<b>REQUEST</b>	Current Zoning: B-2, general business Proposed Zoning: UR-C(CD), urban residential, conditional
<b>LOCATION</b>	Approximately 0.17 acres located on the north side of Wilkinson Boulevard between Holton Avenue and Crispin Avenue.
<b>CENTER, CORRIDOR OR WEDGE</b>	Corridor
<b>SUMMARY OF PETITION</b>	This petition proposes a 3,600 square foot, two-story office condominium building with enclosed parking on the first floor underneath the building.
<b>STAFF RECOMMENDATION</b>	Staff recommends approval of this petition upon resolution of outstanding issues. The petition is consistent with the <i>Central District Plan</i> (1993).
<b>Property Owner</b>	Frederick A. Watson
<b>Petitioner</b>	Frederick A. Watson
<b>Agent/Representative</b>	T. Anthony Lindsey
<b>Community Meeting</b>	Meeting is required and has been held. Report available online.

**PLANNING STAFF REVIEW**

**SITE PLAN**  
 1"=10'-0"

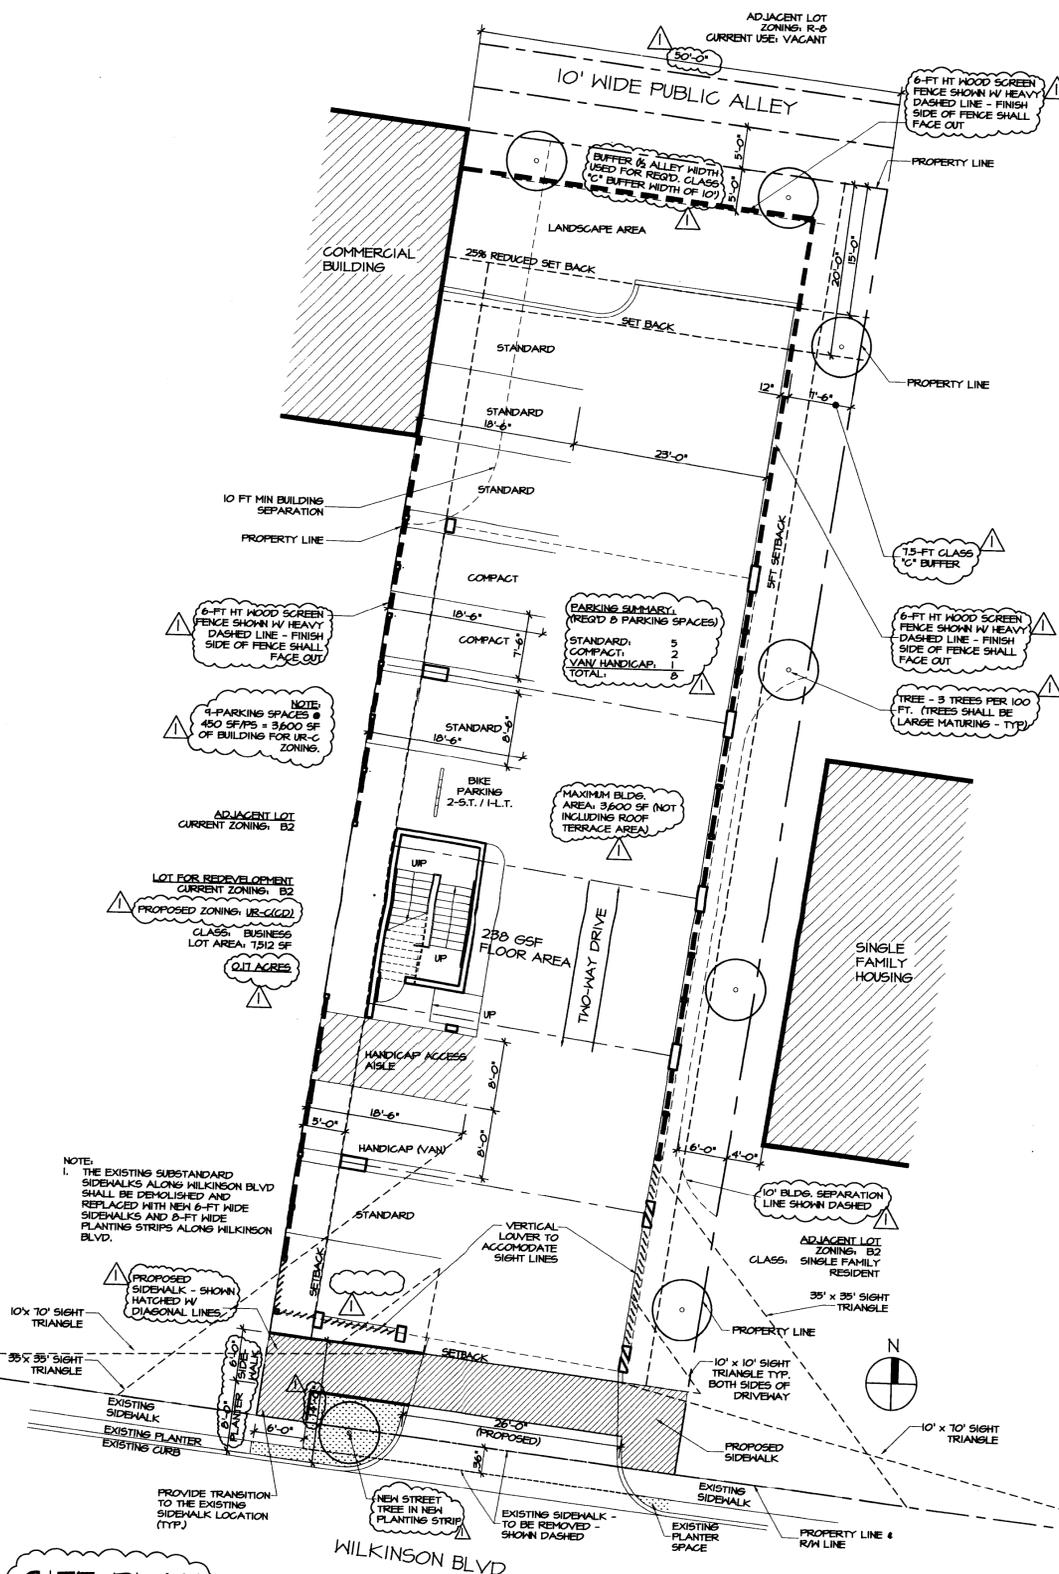
1. The petitioner should revise the site plan to specify acreage.
2. The petitioner should amend the revised note in the body of the site plan to reflect the number of parking spaces provided as eight instead of nine.

3. The petitioner should amend Note 2 under Section 9.407 Development Standards for Various Uses to delete request regarding bonus parking.
4. The petitioner should delete Note 4 under Section 9.408 Off-Street Parking and Loading.

5. The petitioner should delete note under Section 12.301 that no buffer is required between the project and the B-2 zoned property to the west.
6. The petitioner should amend Note 1 under Additional Notes to state that full cut-off fixtures will be used for all outdoor lighting.

7. The petitioner should add a note that a Solid Waste Management Plan will be submitted to Mecklenburg County Solid Waste prior to initiating demolition and/or construction activities. Note should also specify that the site will be fully secured during non-working hours.

8. The petitioner should amend Note 7 under Section 12.301 to delete statement that adjacent site to the north is currently vacant. The site is currently developed.
